WEST SUSSEX COUNTY COUNCIL CONSULTATION

TO:	Arun District Council FAO: Andrew Wood
FROM:	WSCC - Highways Authority
DATE:	1 April 2020
LOCATION:	Downsview Littlehampton Road Angmering BN12 6PW
SUBJECT:	A/16/20/PL Change of use from workshop to workshop storage space and first floor office space with external parking for works coaches. An amendment received.
DATE OF SITE VISIT:	n/a
RECOMMENDATION:	Advice
S106 CONTRIBUTION TOTAL:	n/a

SITE PLAN 1:500 @ A1

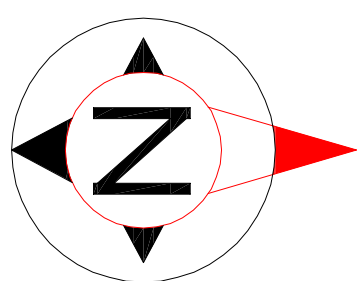
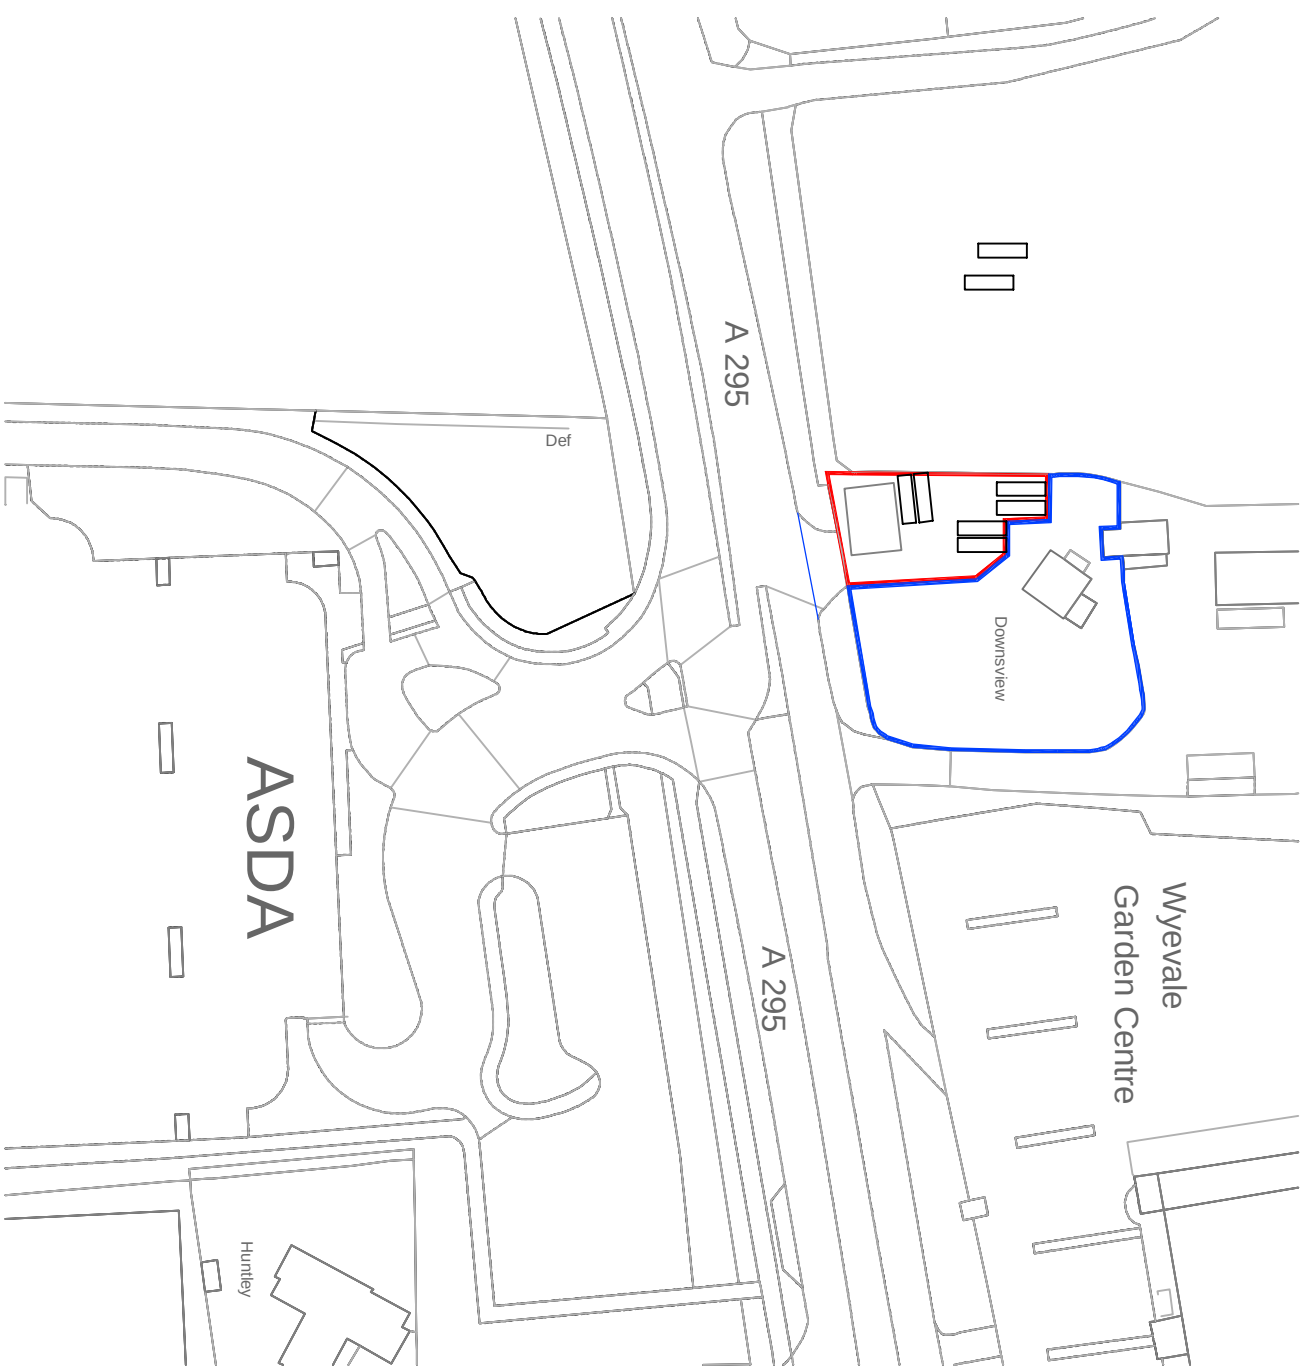
- *'The LHA requested that the applicant should provide the Vehicle Crossover (VCO) dimensions.'*

As discussed above, the applicant proposes that the site will have 12 mini bus trips to and from the site a day. They have provided on plans six parking spaces with space to turn as per Arun Parking Standards.

The applicant has submitted an amended plan demonstrating the VCO being 4.4 metres in width.
